Your ref:	8 Dunstable Mews - APP B Resu...	<b>Please reply to:</b>	<b>Christina Sriramula</b>
Our ref:	20/08249/FULL	Tel No:	07866033879
		Fee Queries:	0207 641 6500;
		Email:	planningreception@westminster.gov.uk;
Miss Nadine James Montagu Evans LLP 70 St Mary Axe London EC3A 8BE		<b>Incomplete Applications</b> Development Planning City of Westminster PO Box 732 Redhill, RH1 9FL	
		31 December 2020

**Address: 8 Dunstable Mews, London, W1G 6BT**

**Proposal: Replacement of doors at ground floor, replacement first floor front and rear windows with double glazed timber windows, works to the downwards alignment of the down pipe, repainting of existing window cills and the replacement of current roof lights, raising of the roof panels, and associated works.**

Thank you for your application received on 22 December 2020. I am writing to inform you that your application is incomplete for the following reason(s):

Project		
8 Dunstable Mews, London, W1G 6BT		
Client		
Martin Lamb, Esq.		
Drawing		
Proposed Sections		
Drawn	Initially drawn	Scale
--	10/01/2021	1: 50@A1 1: 100@A3
Job number	Drawing number	Revision
043	007	P01

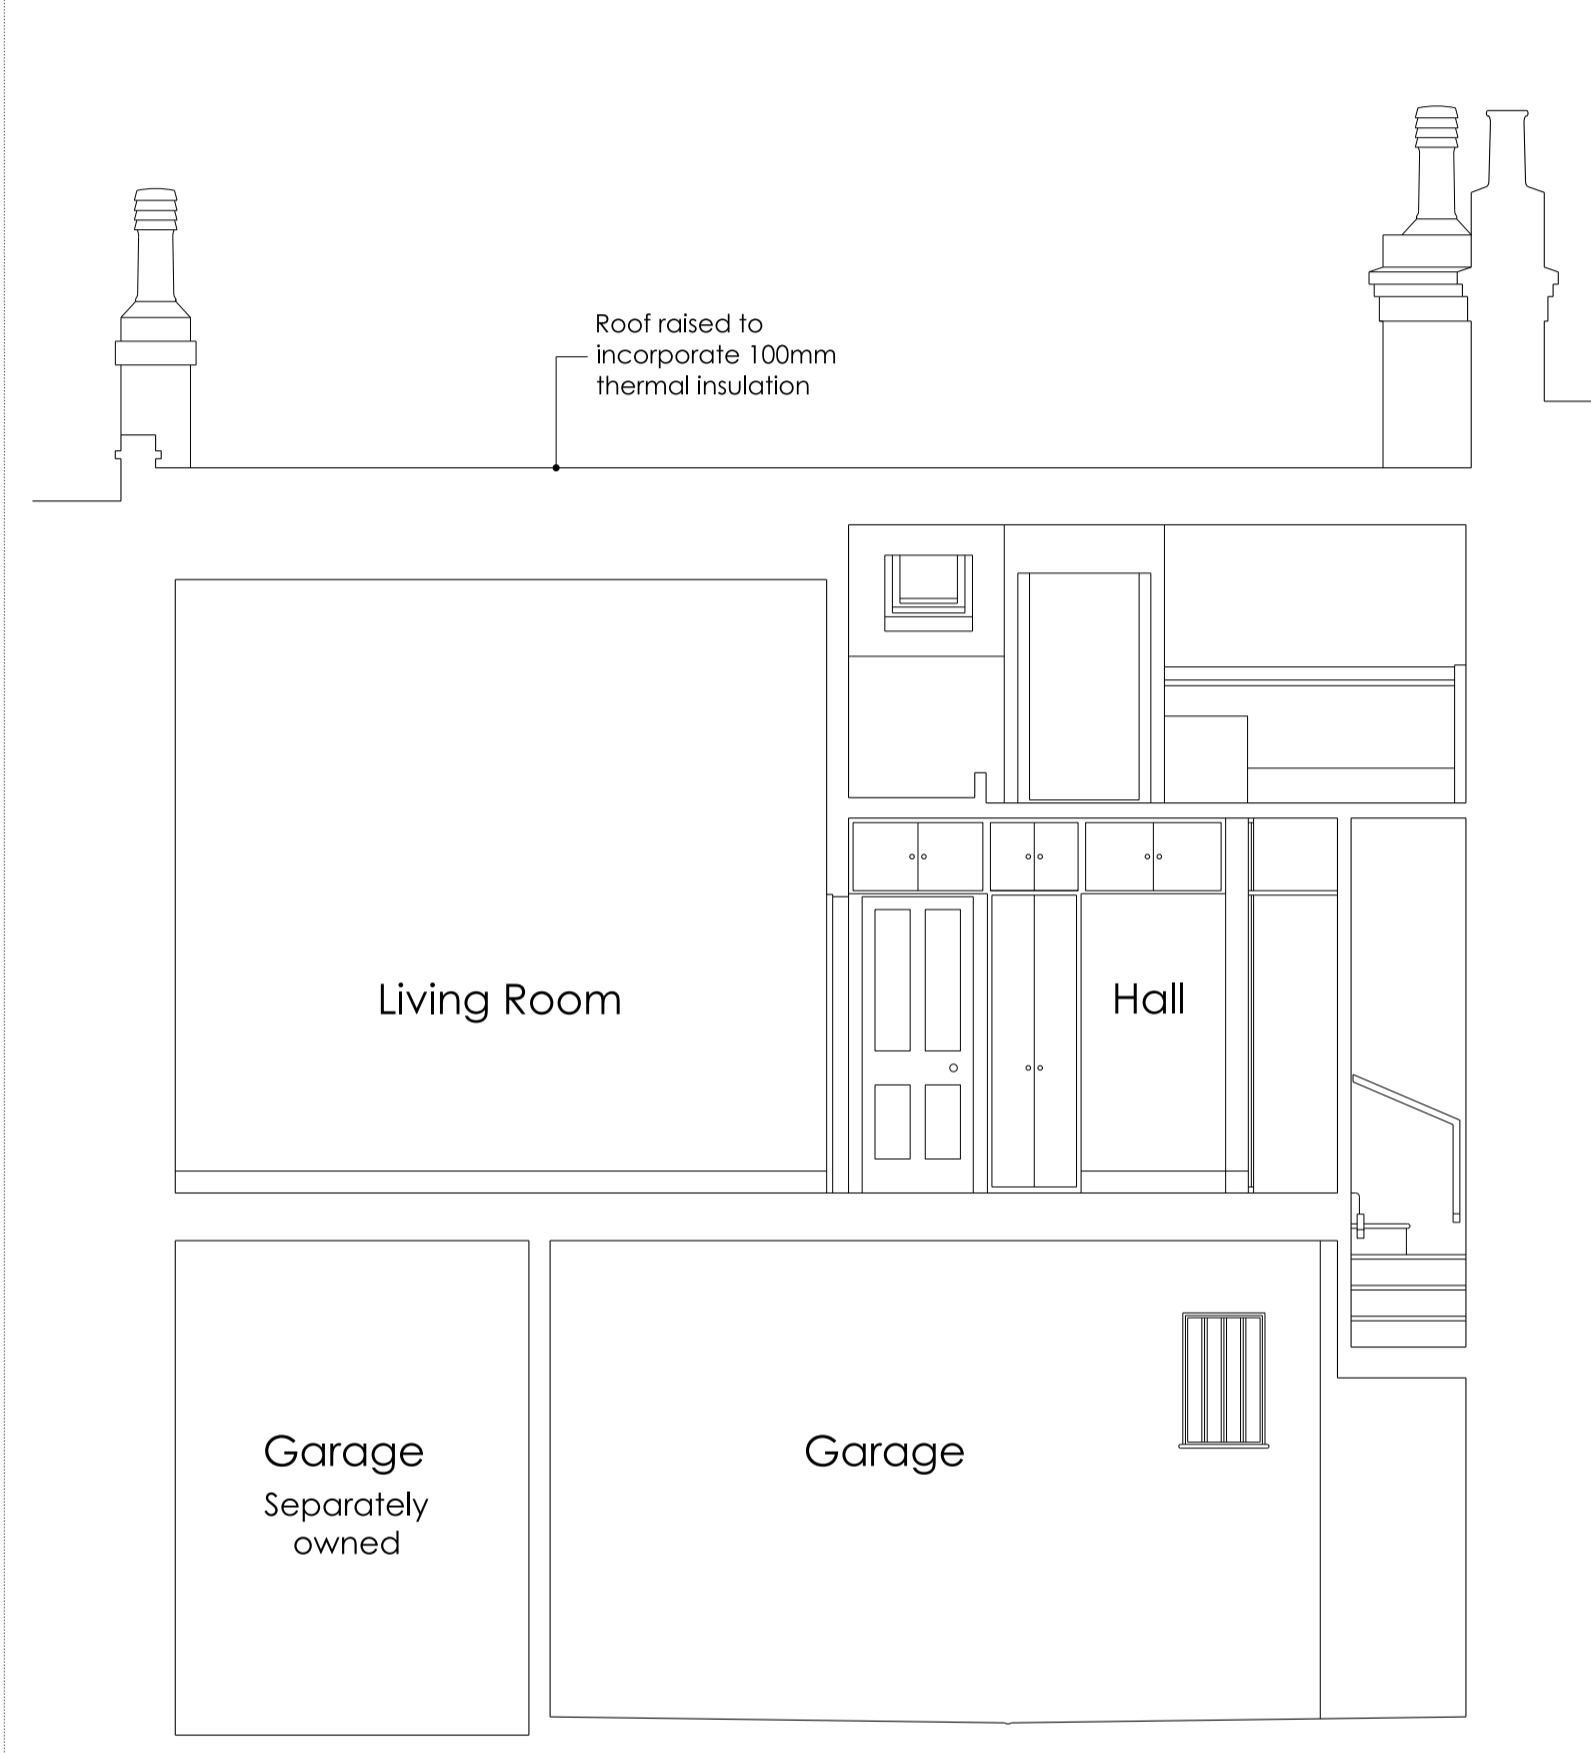
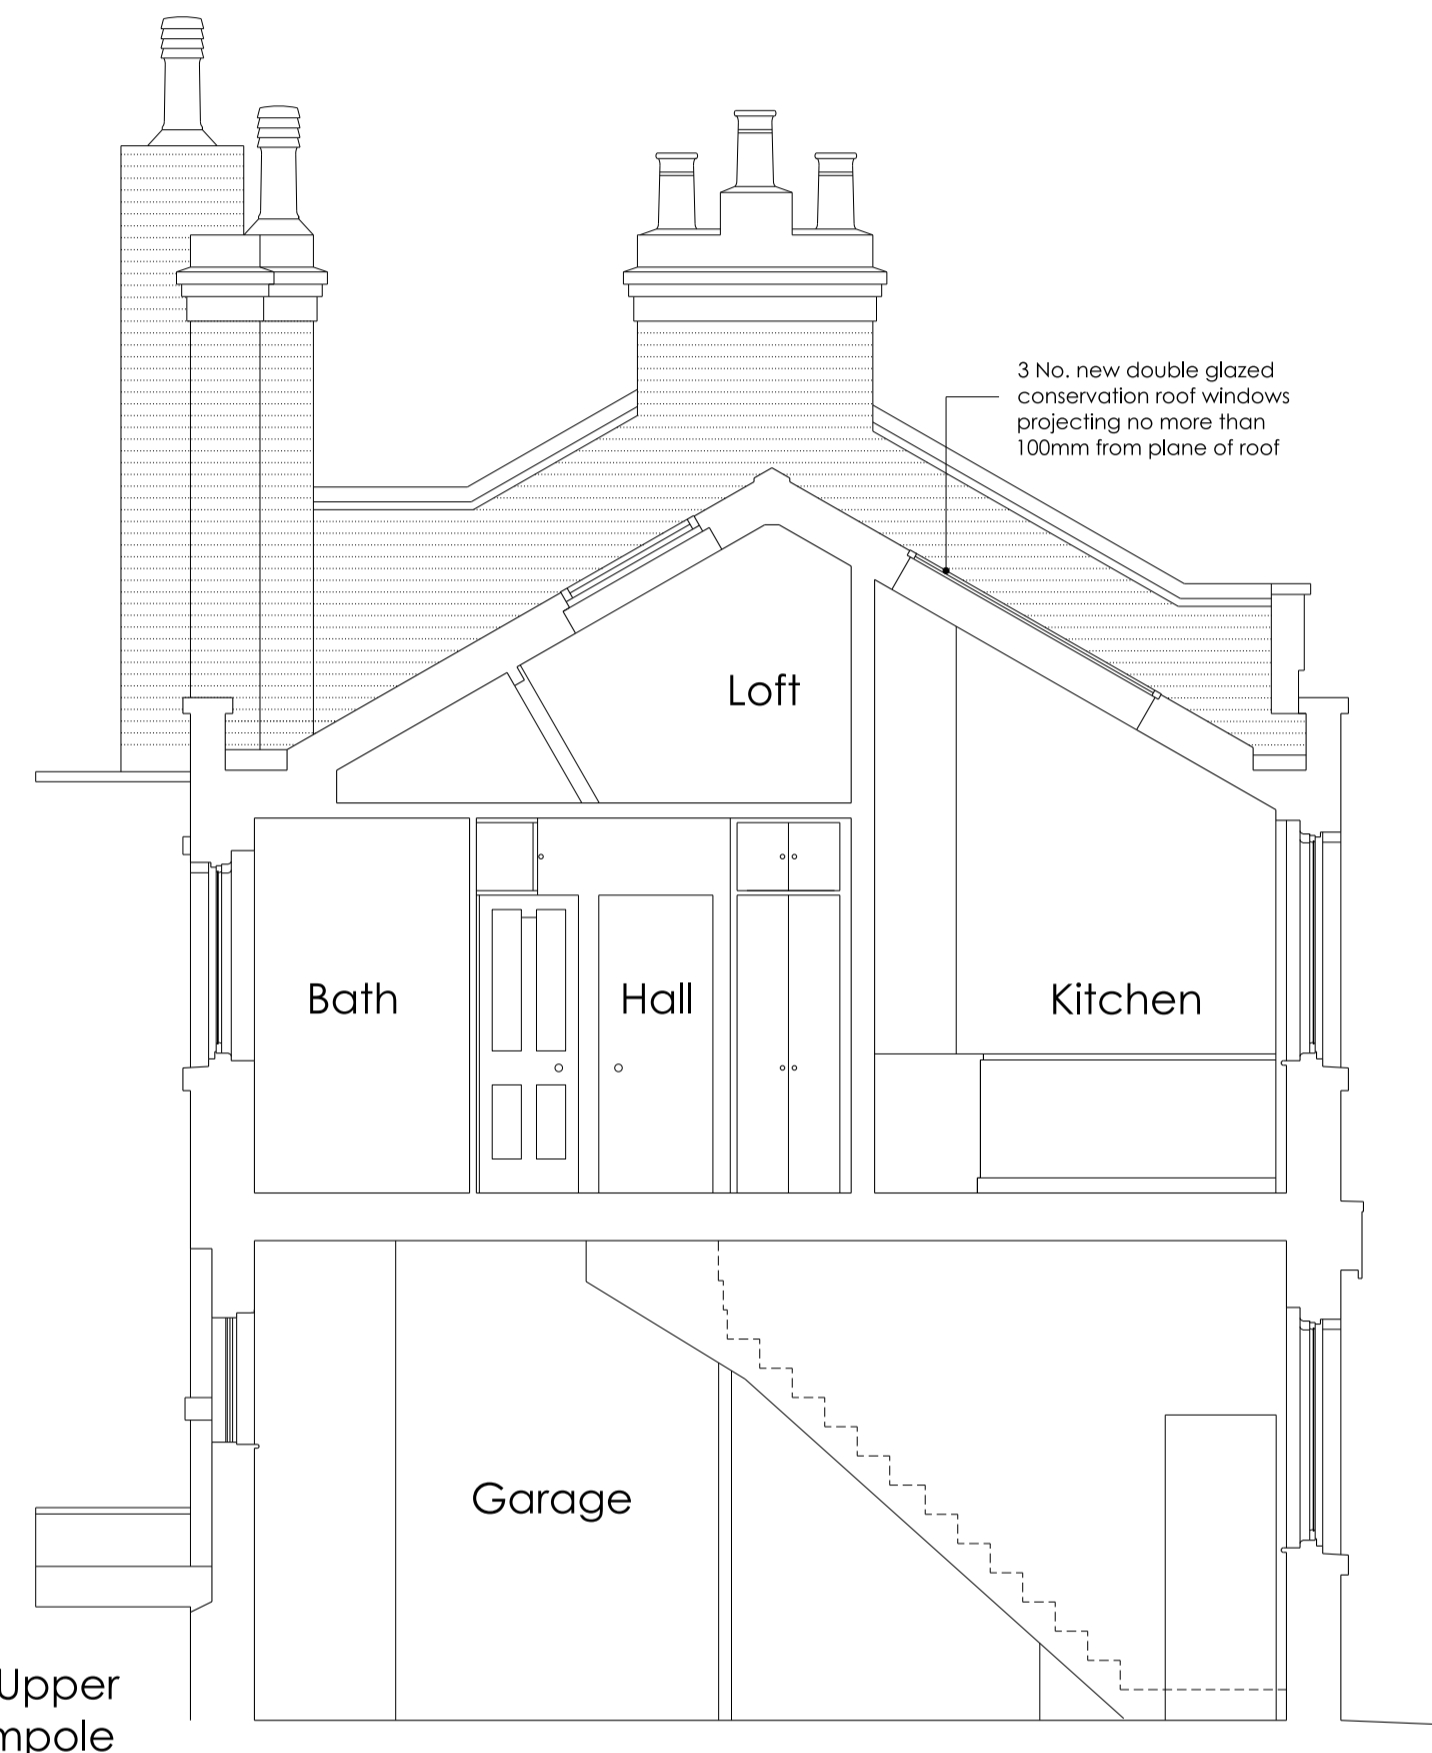
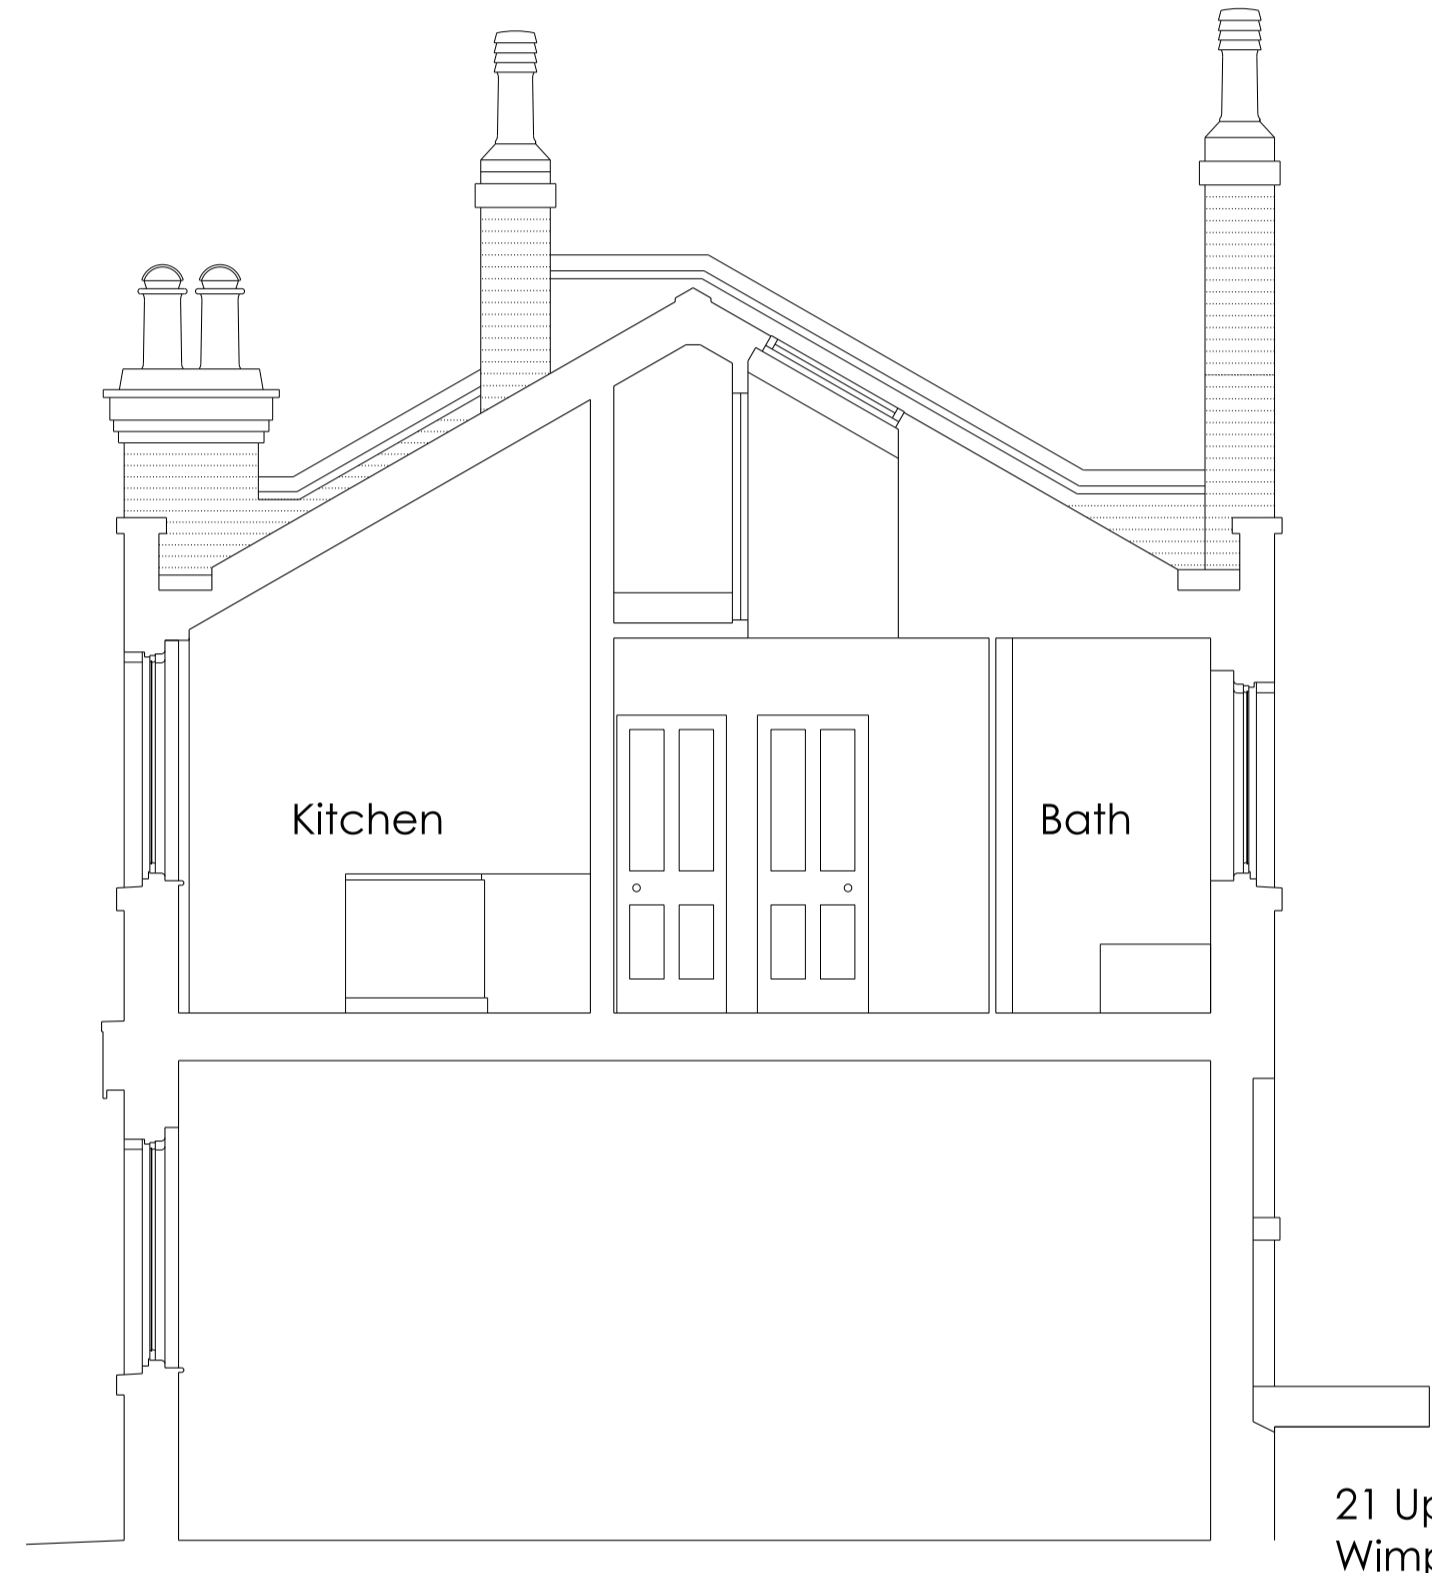
- PROPOSED sections to show raised roof
